**FACULTY OF ARTS AND SOCIAL SCIENCES, UNIVERSITY OF SYDNEY,
CAMPERDOWN CAMPUS (SSD 7081)**

HERITAGE COUNCIL'S SUBCOMMITTEE'S COMMENT – 8 JULY 2016

FACULTY OF ARTS AND SOCIAL SCIENCES, UNIVERSITY OF SYDNEY, CAMPERDOWN CAMPUS (SSD 7081)

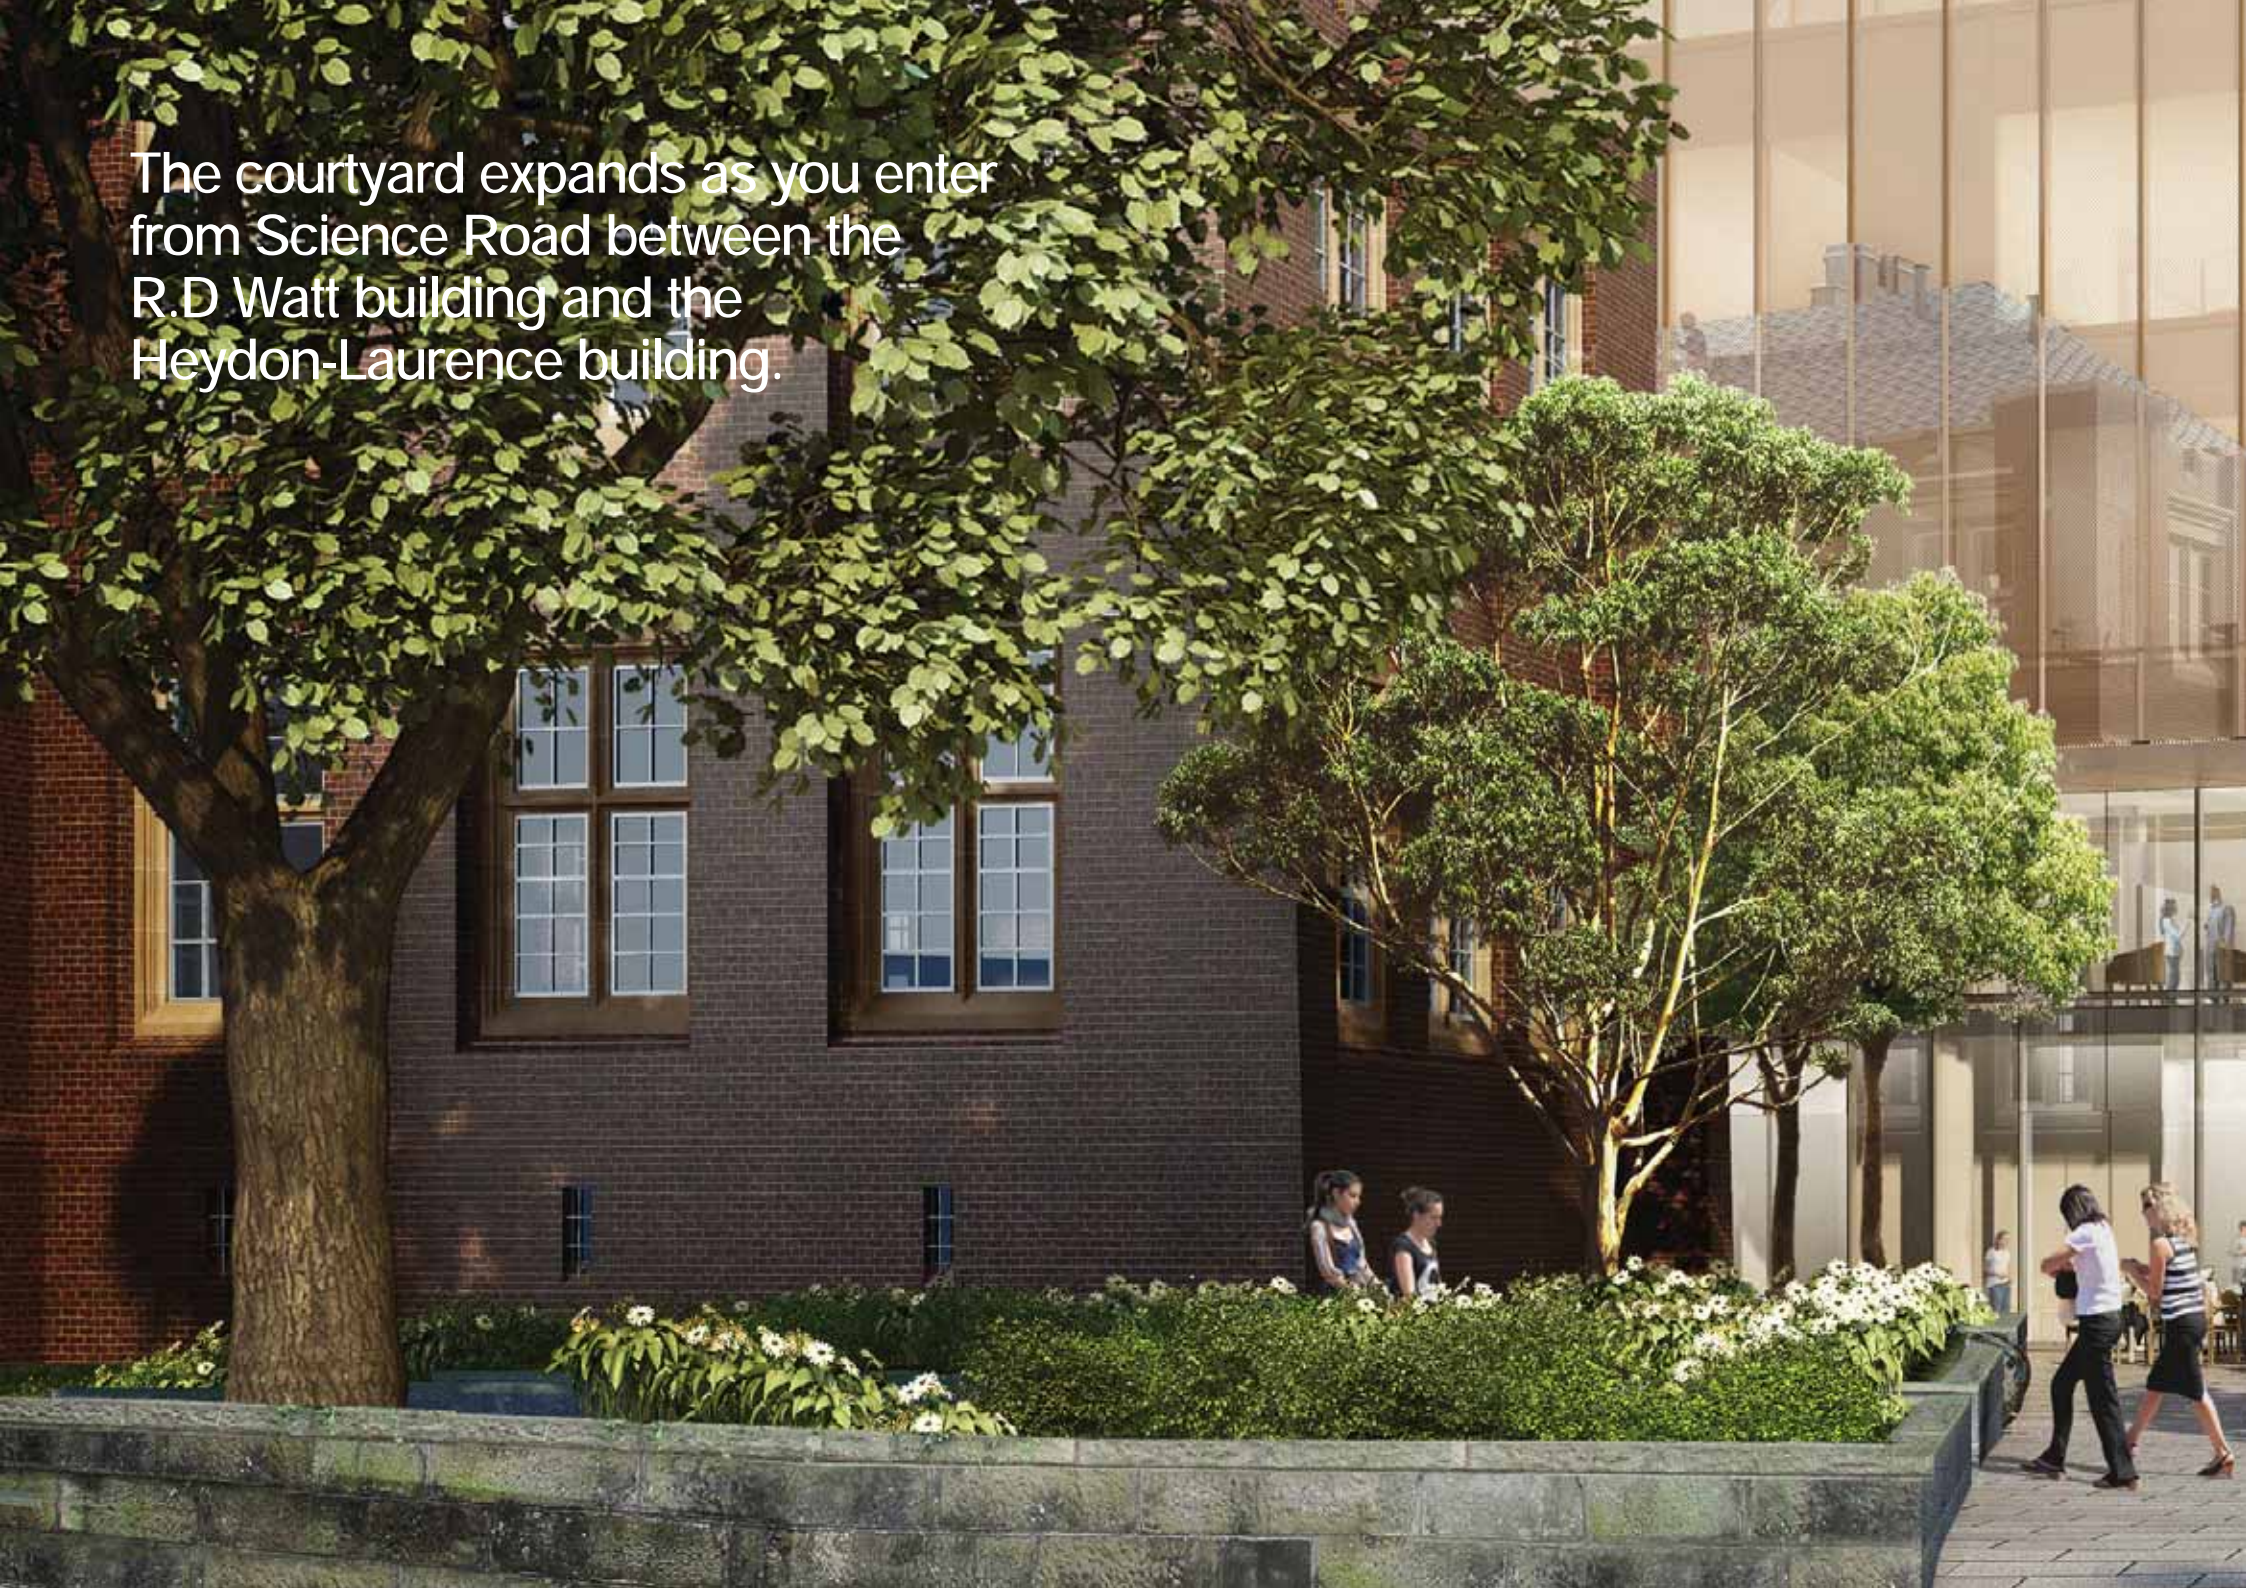
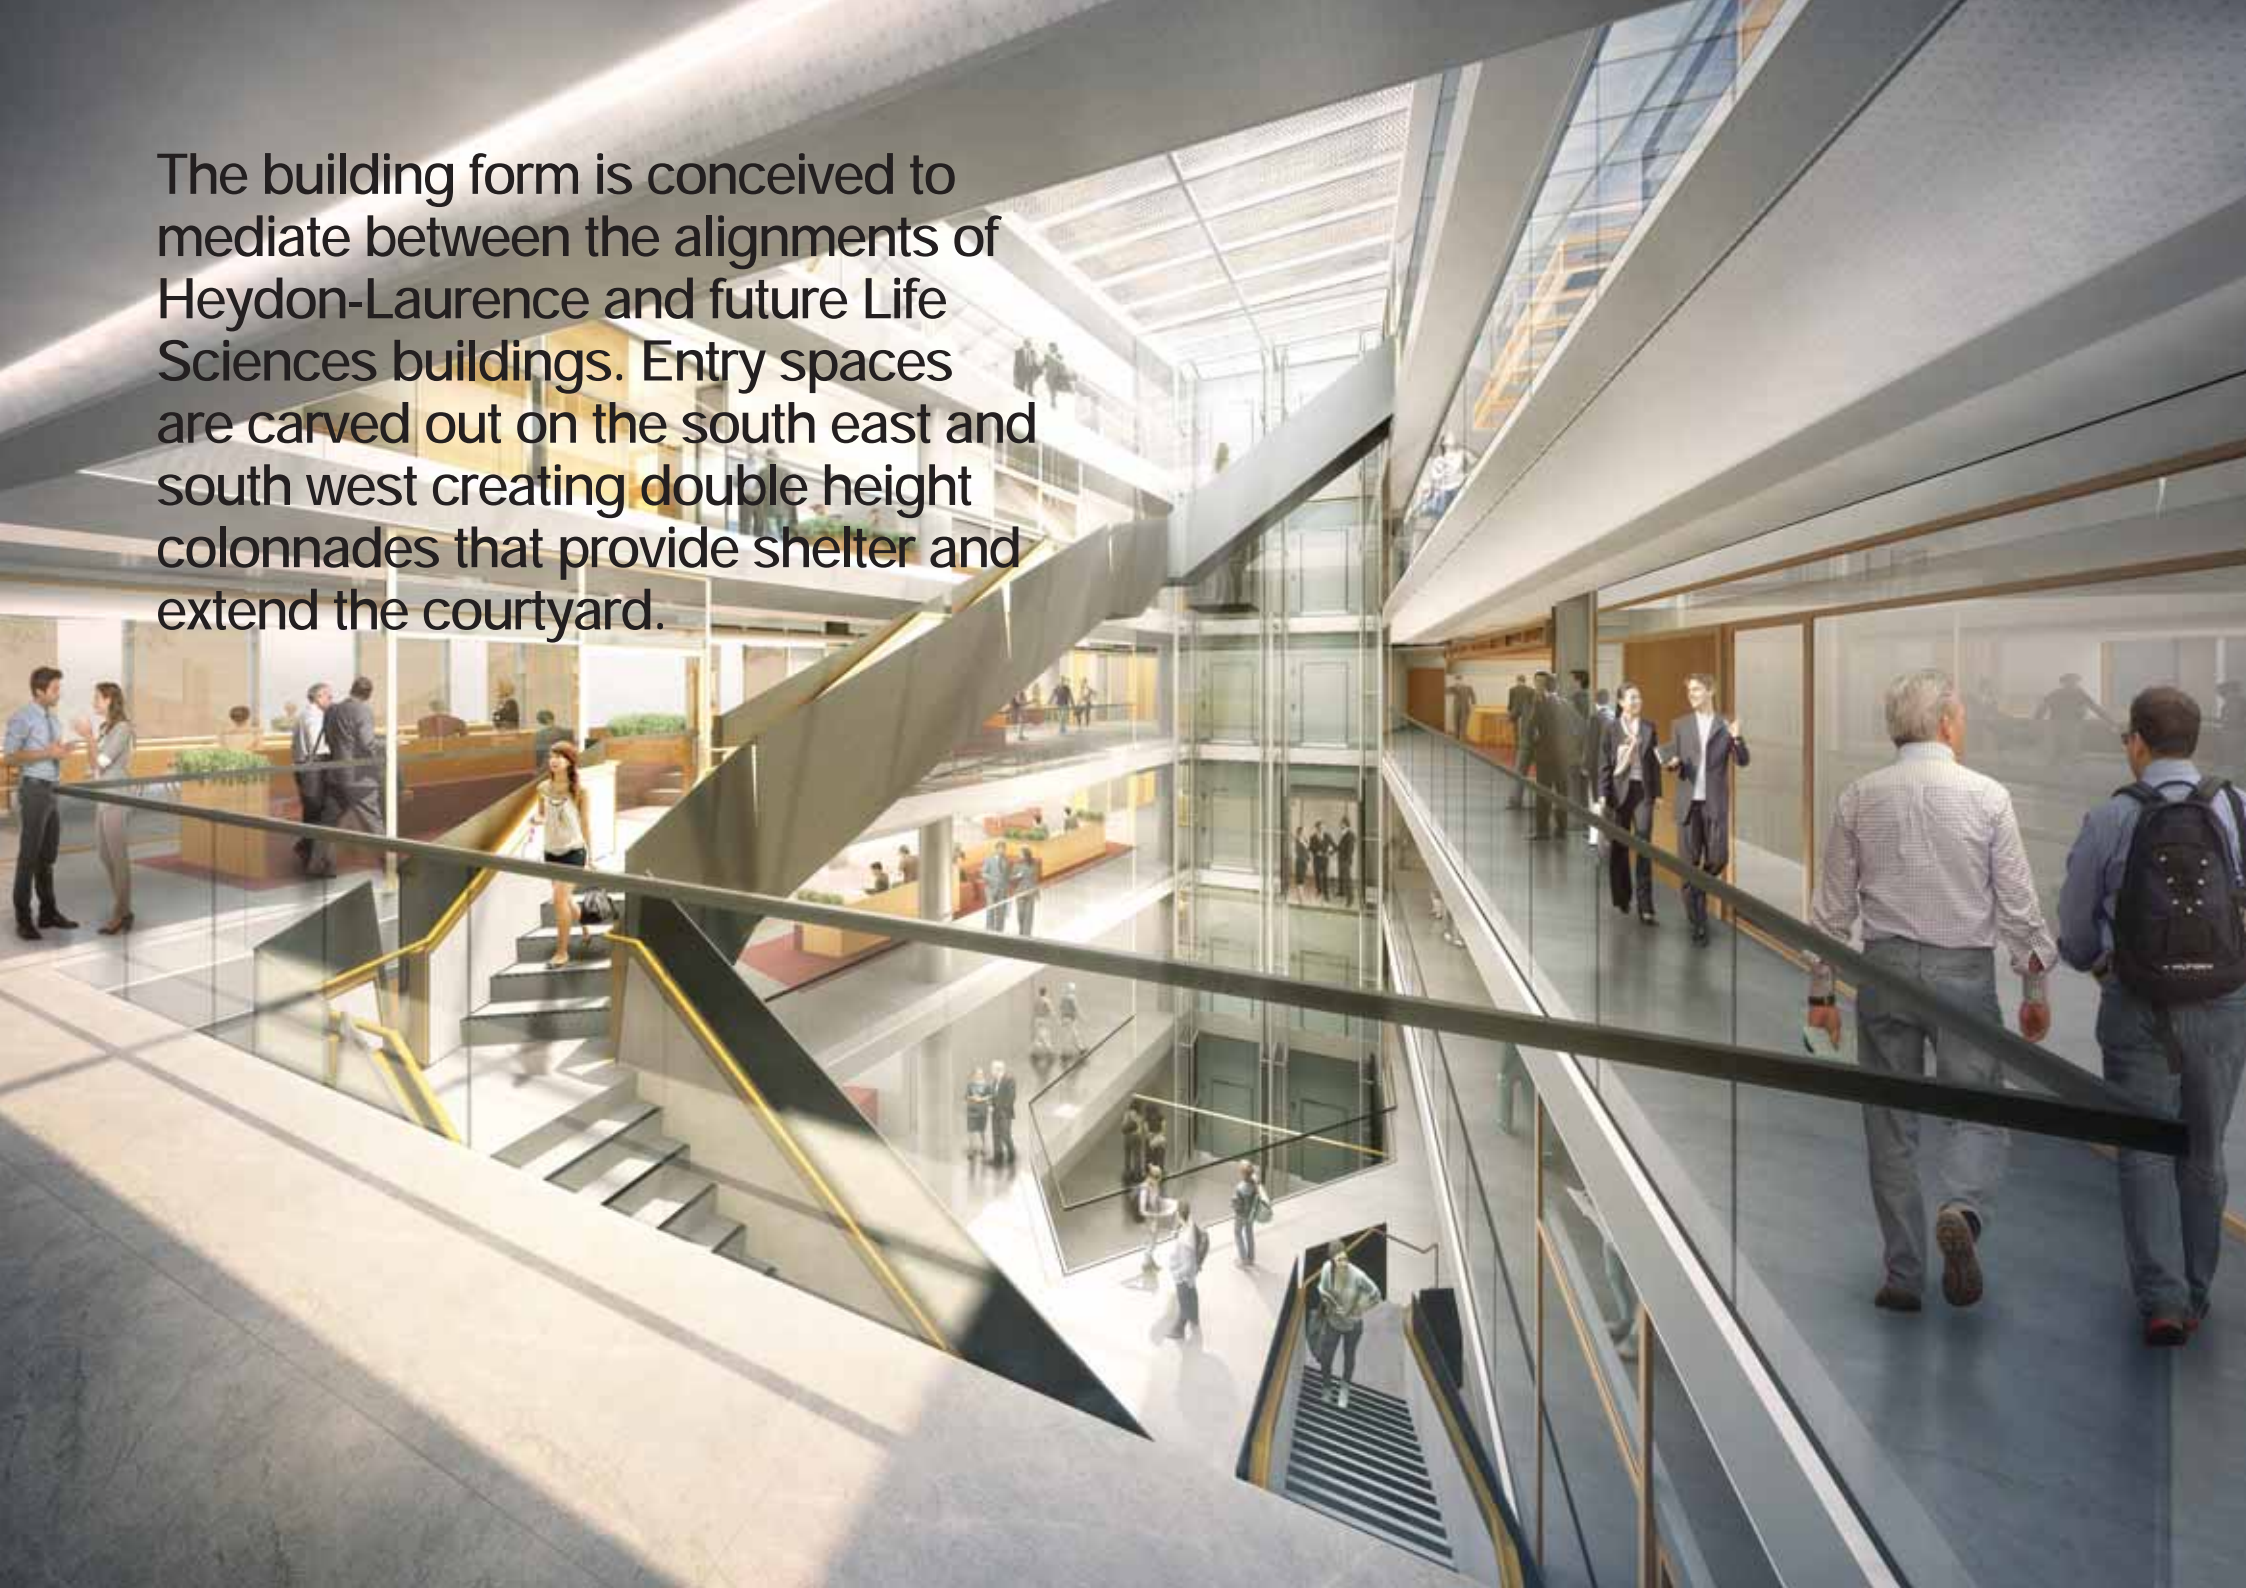
The FASS proposal provides a clean separation between the heritage building and proposed new building but the courtyard does not demonstrate a sympathetic abutment to the rear (north façade) of the R.D. Watt Building.

The architectural relationship between the R.D. Watt Building and the FASS proposal needs further refinement, in terms of their internal spatial arrangements and relationship with the shared courtyard spaces; and further setback of the proposed FASS building's southern façade is needed to ensure an appropriate setting is retained around the R.D. Watt Building (refer to montage entitled *South Façade and RD Watt, viewed from Campus, Science Road*).

The character and materiality of the courtyard spaces should enhance the architectural relationship between the R.D Watt Building and the FASS proposal. Further refinement of the courtyard spaces is required to improve the spatial quality.
